Recommendation Report for Listed Building Consent for Alterations, Extension or Demolition of a
Listed Building

REF NO: P/163/21/L

LOCATION: Pennicotts Farm
Pagham Road
Pagham
PO20 1LN

PROPOSAL: Listed Building consent for the demolition of existing conservatory to southern side of building & general repair & maintenance of external brickwork & roof coverings, insertion of 2 No conservation style rooflights to the rear valley roof, & formation of 2 No sets of double patio doors within existing window openings on the northern elevation. Internal alterations comprising the removal of partition walls, reinstatement of wooden balustrade to staircase, and general repair, maintenance and refurbishment.

House A Staircase

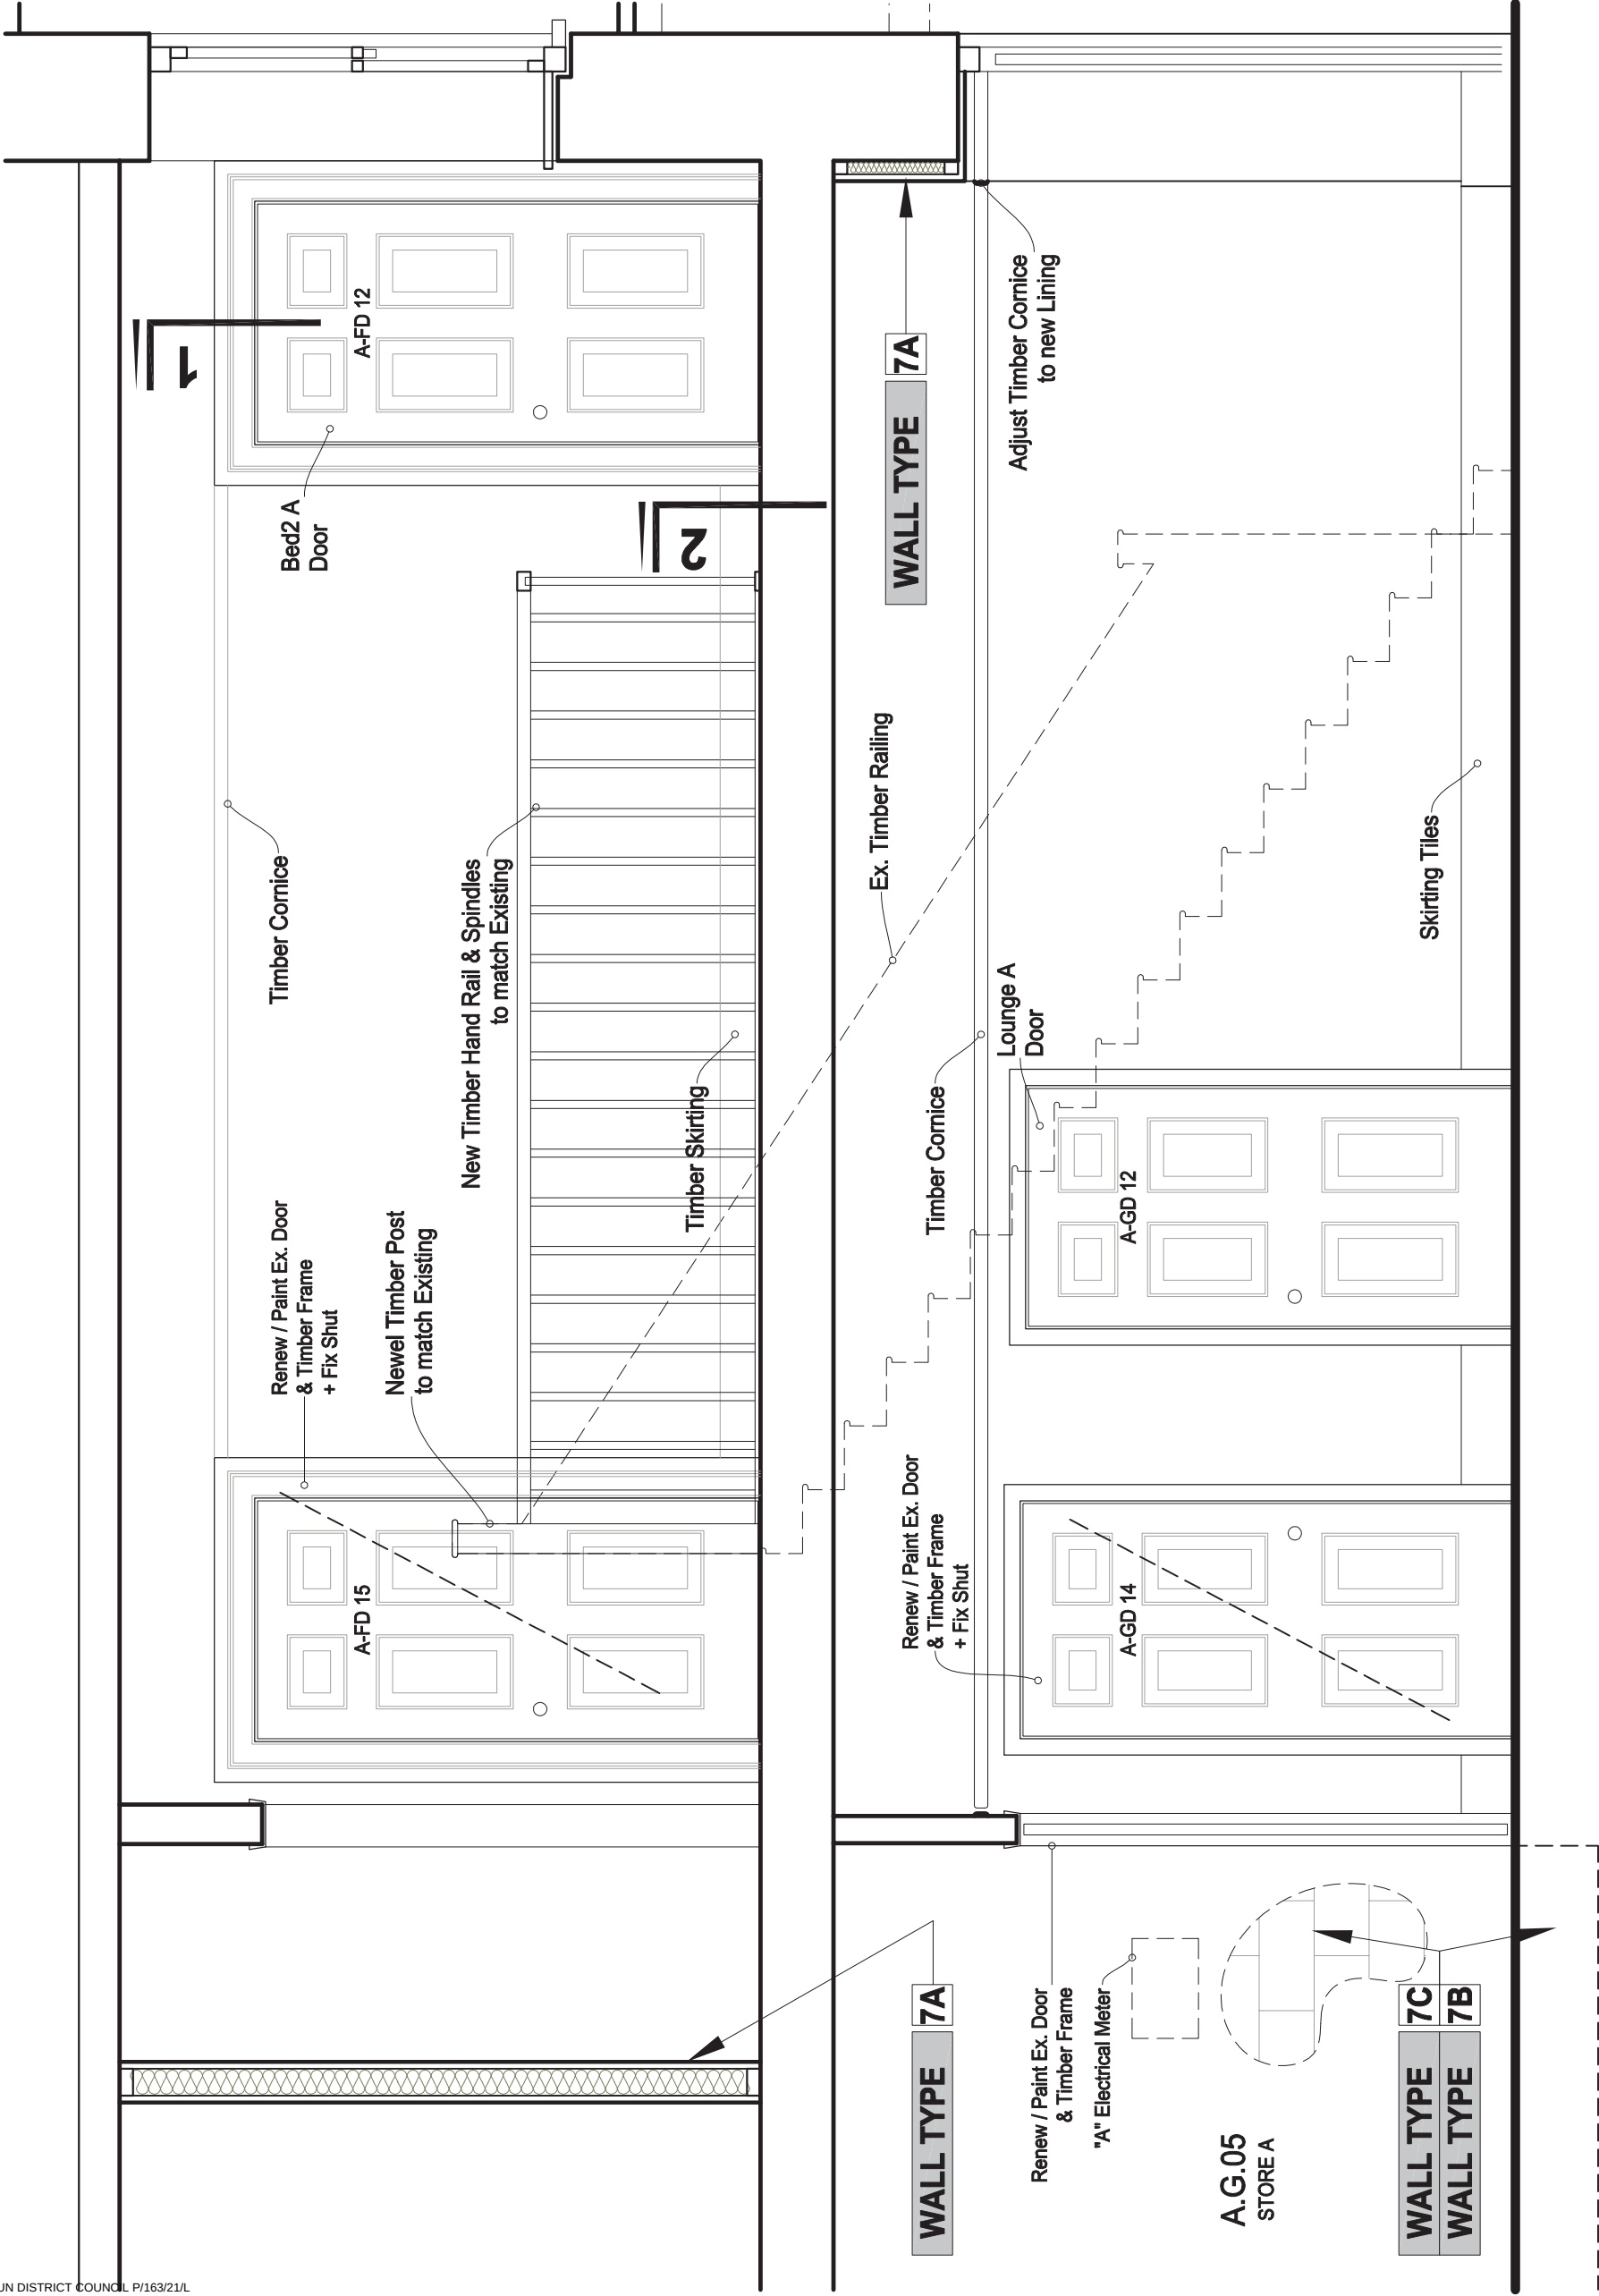
On the floor plan (FF Plan Structure) and 'House B FF Staircase' it looks as though door A-FD15 is removed (reference is made to 'block up opening'), where as in both the plans showing the 'section for house A staircase' (House A section staircase B-B section) and 'House A FF Staircase', the door is to be fixed shut, however again unclear which one is relevant and only the latter is the acceptable approach. There is another door which will be blocked up and the door recycled, without justification on the first floor of landing B. It is not clear from the various plans what would happen to the 're-cycled' doors.

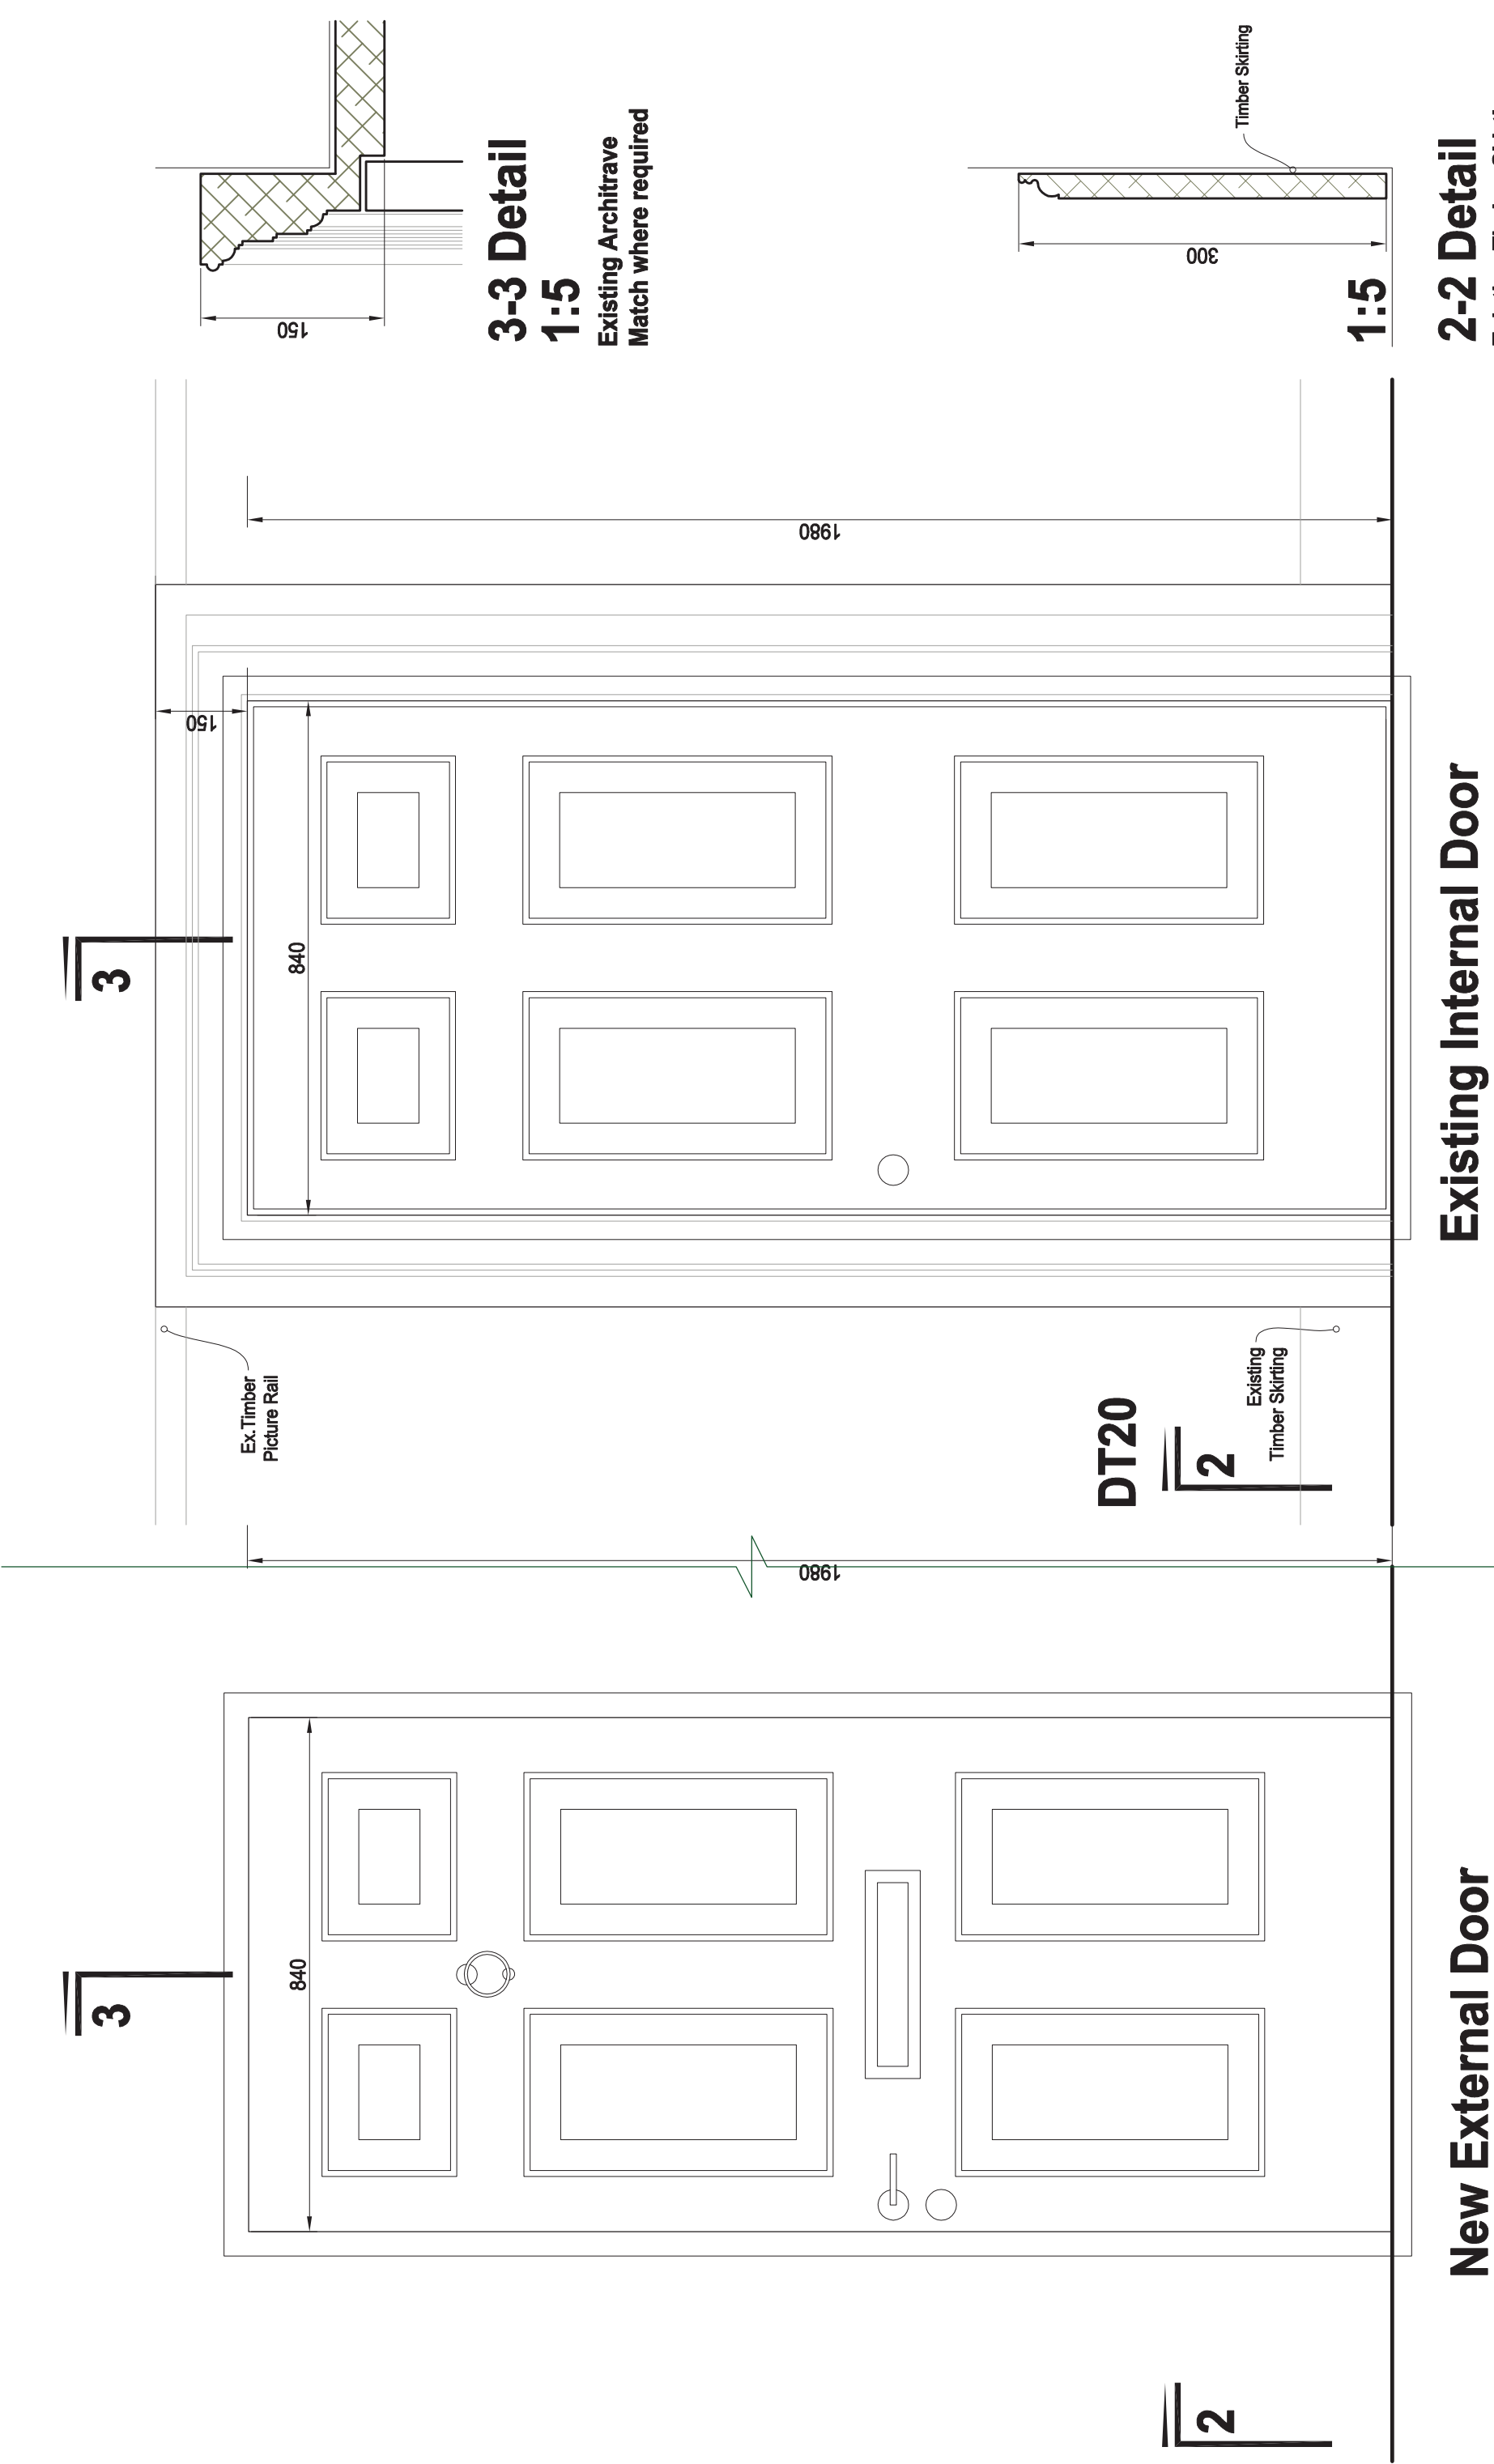
References and drawings identify that insulation is to be 'injected into the walls and then new plaster added.' It is not clear how such an approach will allow the building to 'breathe'. This is to be followed by MDF skirting boards, which is not necessarily appropriate for a listed building (see one of the 'Details' drawings). It is not clear how the existing laths and studs will be maintained (a Newton membrane added to the rear of the wall).
